From: Joe Robertson
Sent: 03 May 2017 13:14
To: DCAdmin
Cc: Catherine McGuigan
Subject: 2017/91093 Old bank Works Slaithwaite

There are protected trees, both TPO'd and trees protected by the conservation area, on land adjacent to this site which would need to be taken account of in the proposed design.

The arboricultural survey logged on the file is actually a topographical plan, not a tree survey, so does not address the trees. To be able to fully assess the impact on the adjacent protected trees we need to see a tree survey, arboricultural impact assessment (to include shade patterns) and arboricultural method statement, all in accordance with bs 5837. This should really have been provided at the point of submission.

PROPOSED SITE PLAN (1:200)

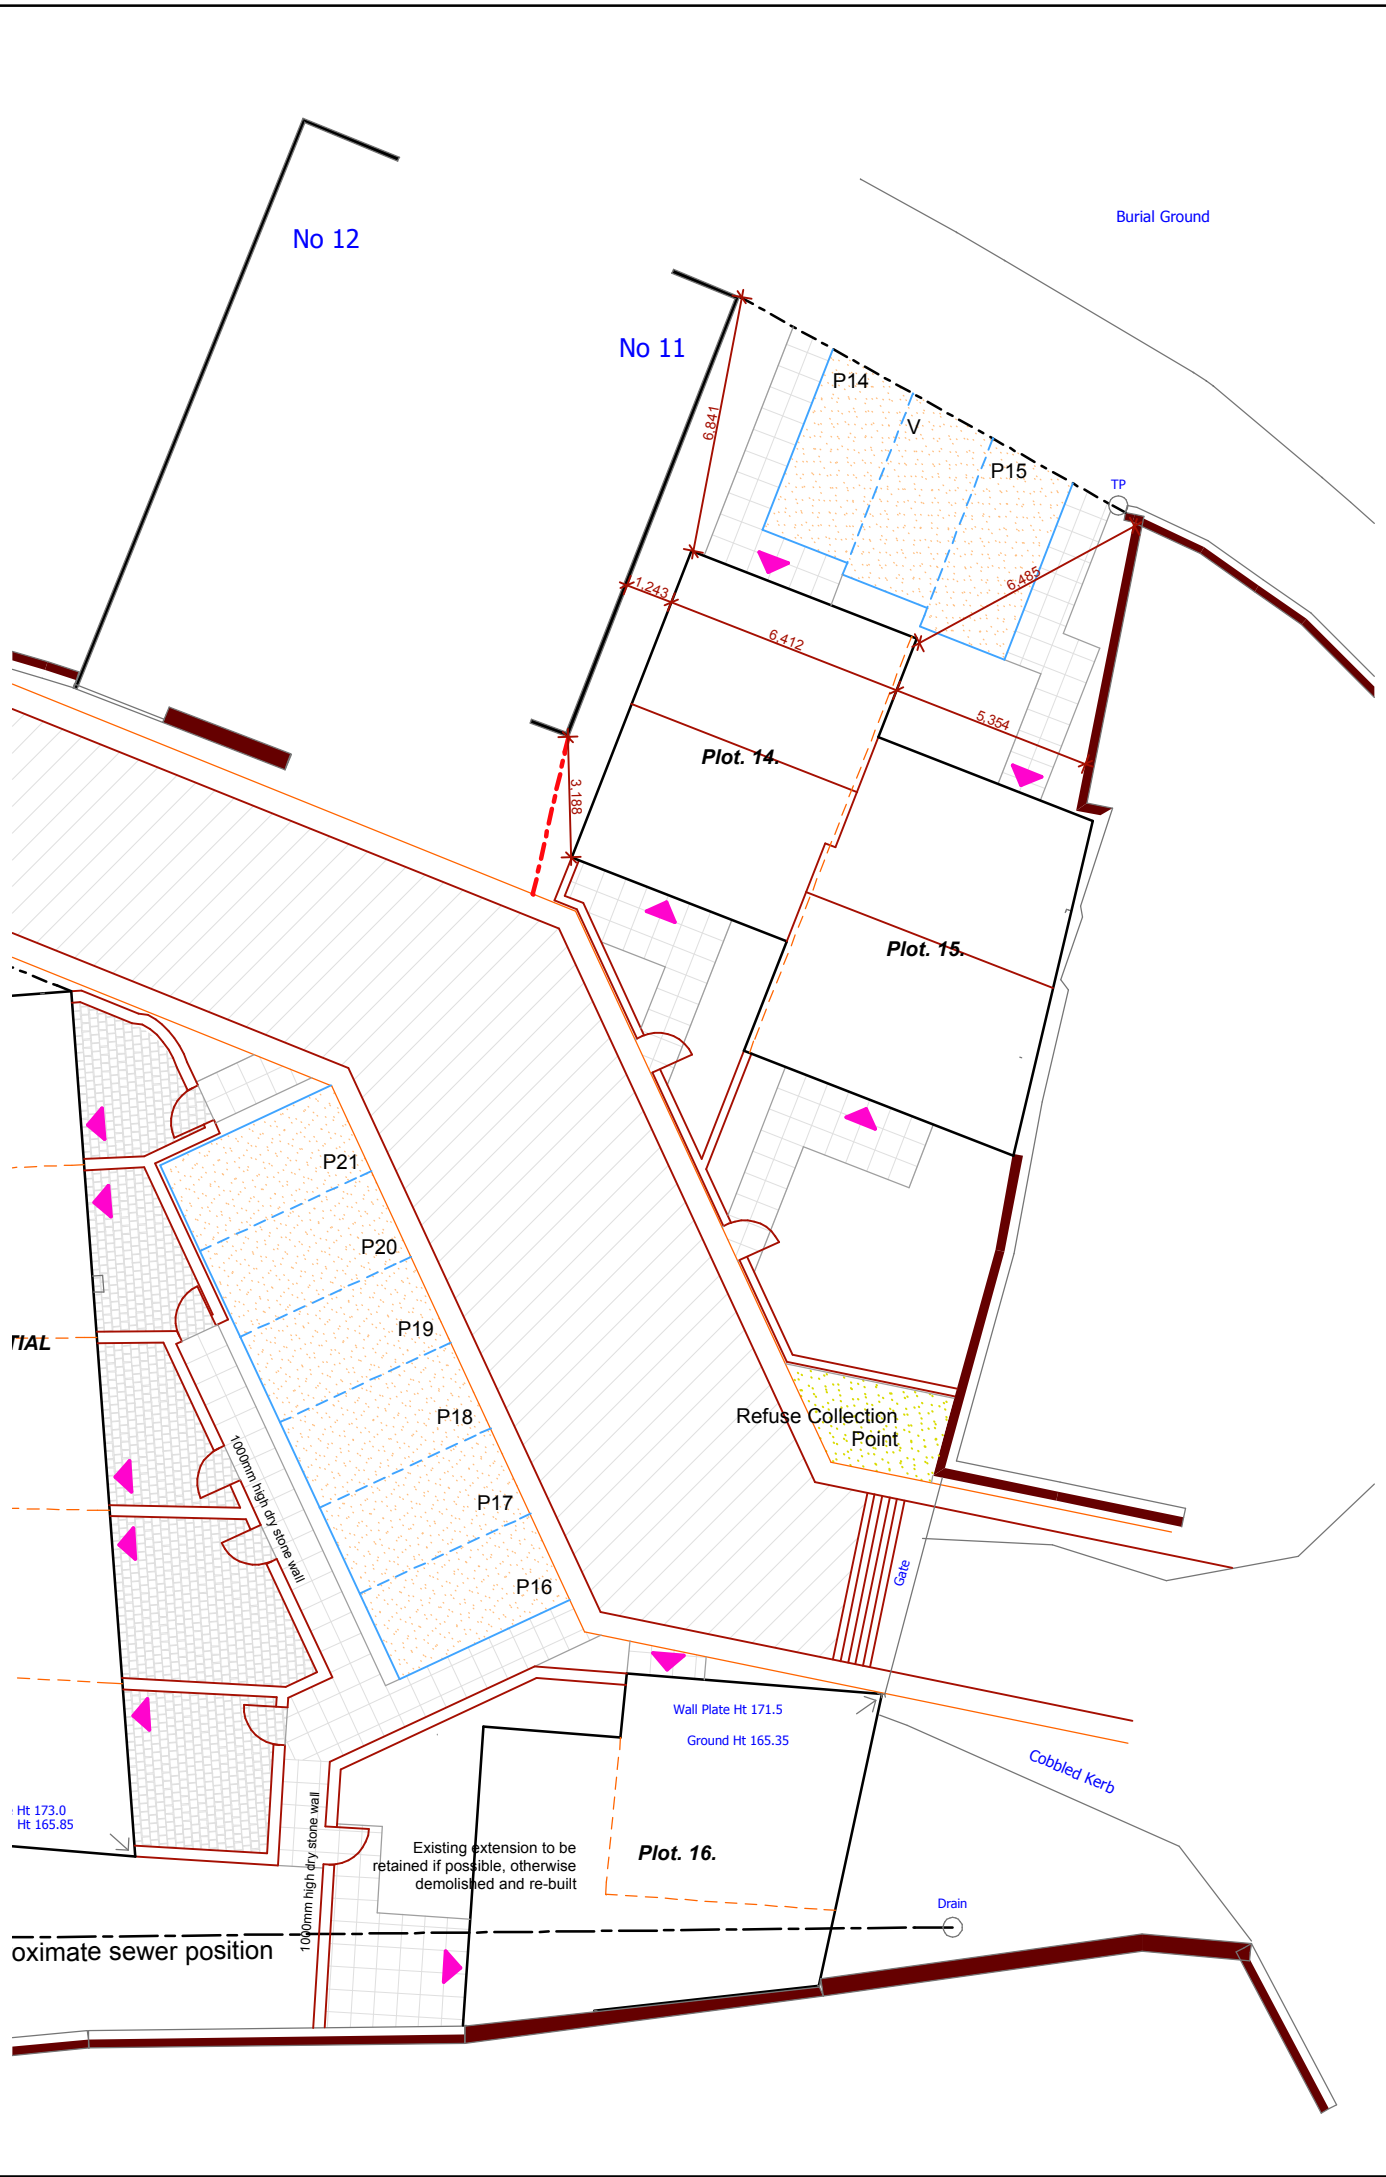
On the basis of the current information, two dwellings here would not be something that I could support, due to possible impact on protected trees (UDP policy Ne9 and Be2 would apply) and no information has been provided to demonstrate that this would not be the case. Although I'd be happy to assess the above mentioned arboricultural documents if they are submitted.
